WAYNFLETE LOWER SCHOOL - ADDENDUM #2

date: Monday, February 06, 2017
project: Waynflete Lower School Addition & Renovations, 2013-0050
prepared by: Austin Smith Scott Simons Architects
to: Cordelia Pitman Wright Ryan Construction
Rick Bergeron Wright Ryan Construction
Luke Dione Wright Ryan Construction
Anne Hagstrom Waynflete School
Patrick Boure Waynflete School
Phil LaClaire PML Project Management

Subject: Addendum #2 to Bid Documents of January 12, 2017

NO SCALE

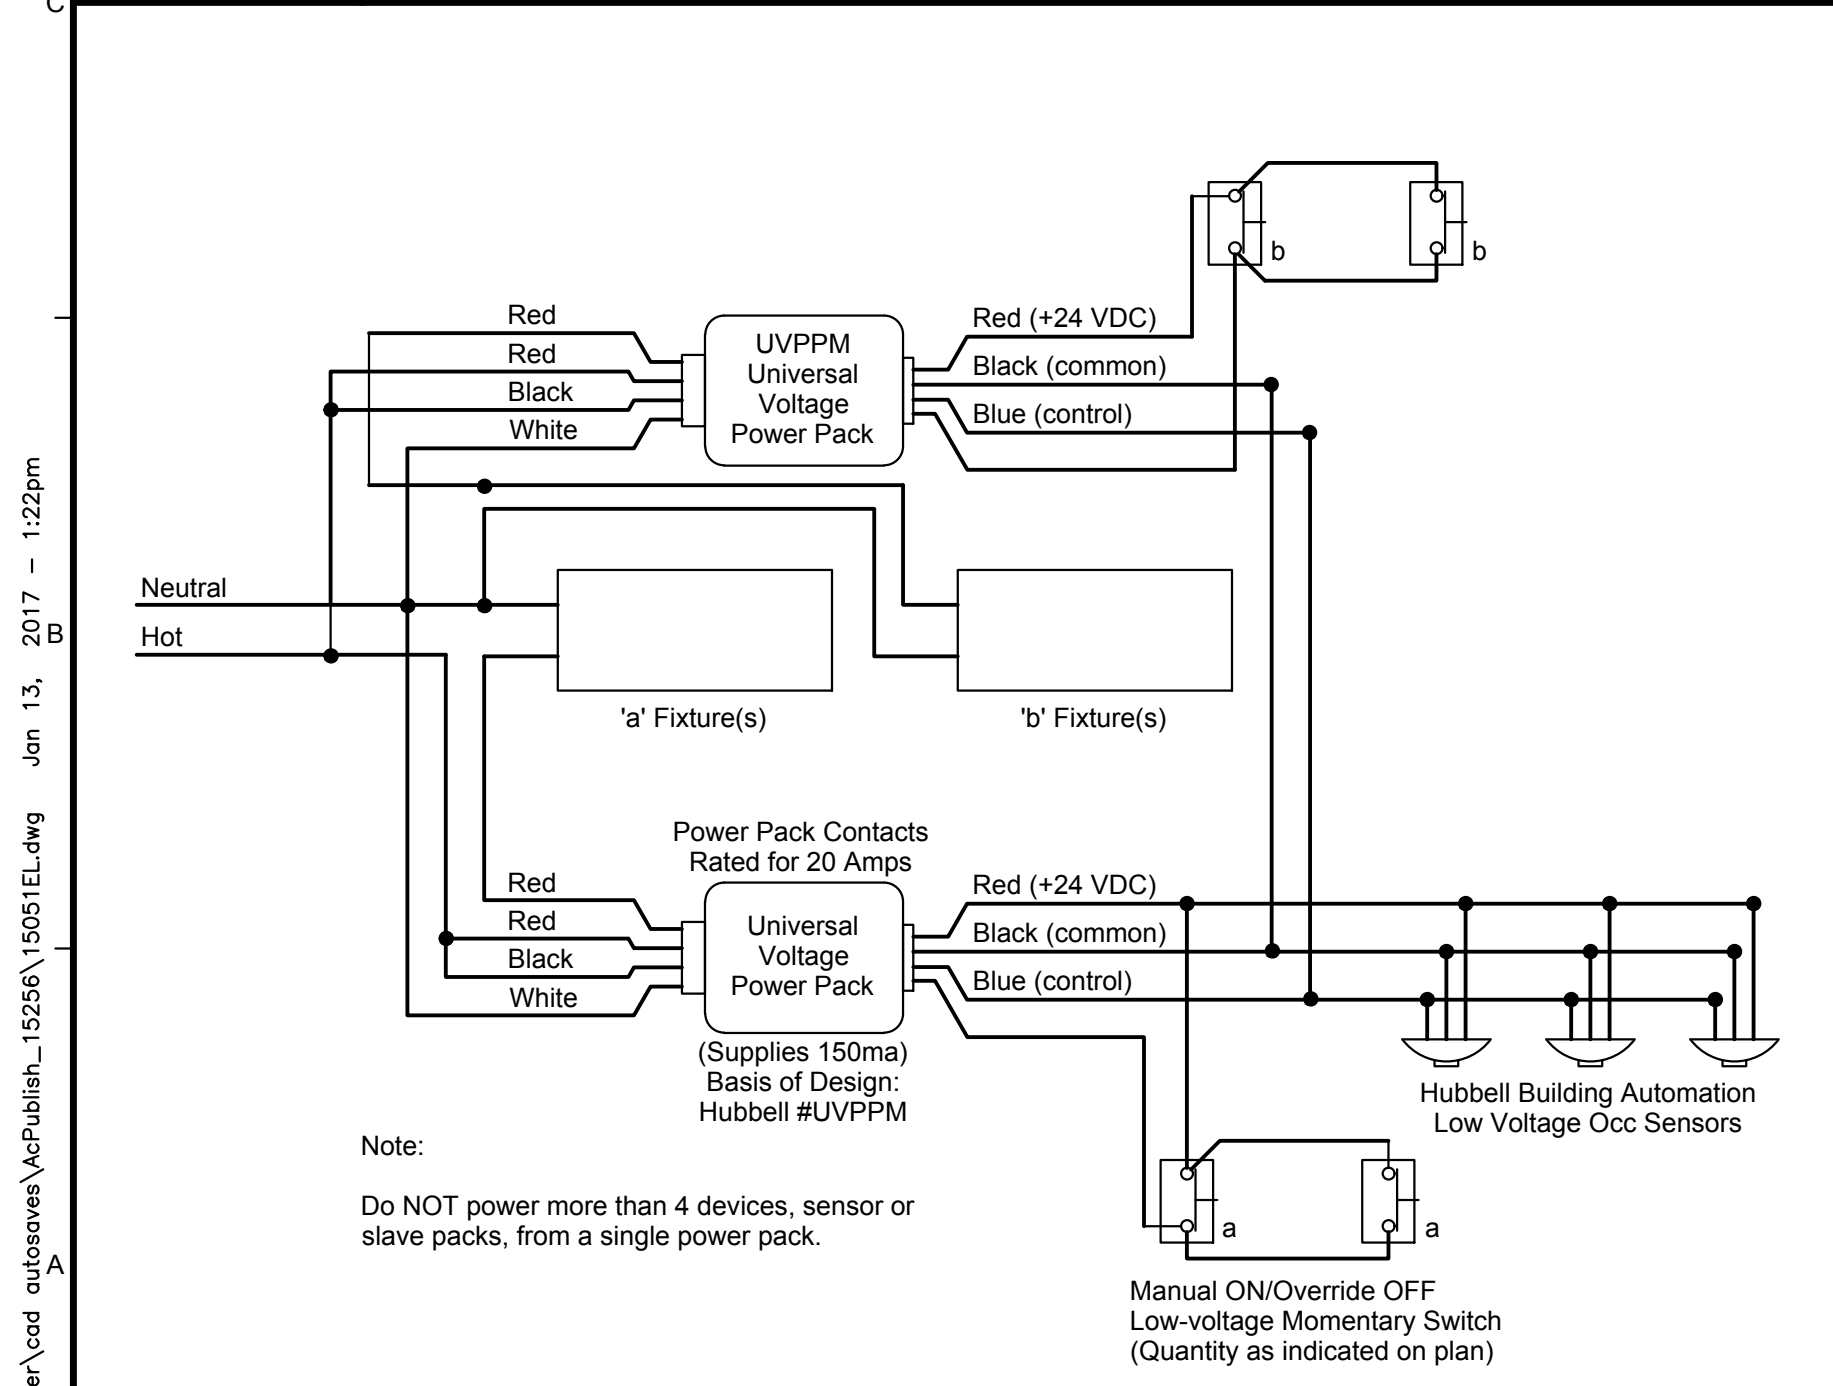
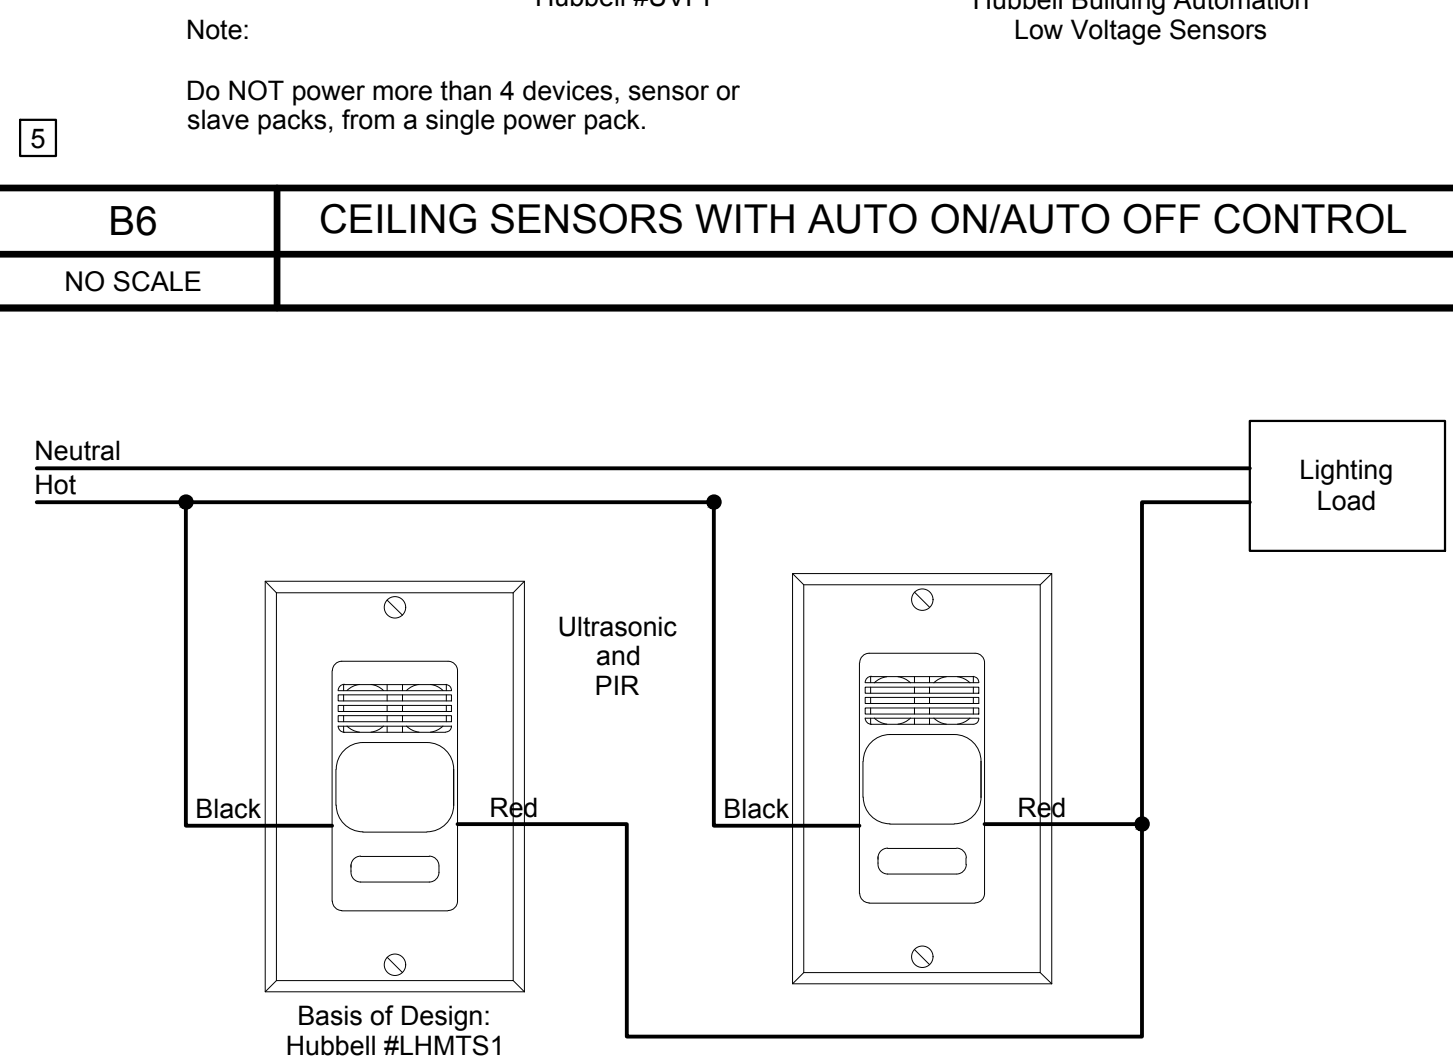
- 2-Q26 Question 26 Dwg I-101 dumpster pad What type of reinforcing is required ?
A: At Dumpster Slab, use #4 reinforcement at 12" OC each way.
- 2-Q27 Questions 27 Q: EL500, there is no wiring diagram detail that corresponds to
Keynote 9. Keynote 9 is used in several locations. Are we to wire room 205
(EL103) as 1 multi-zone room or as 5-6 individual rooms; typical of other
classroom wings?
A: Each separately tagged room with a lighting control note tag shall be wired as
an individual room. Refer to attached revised lighting drawings for further
information.
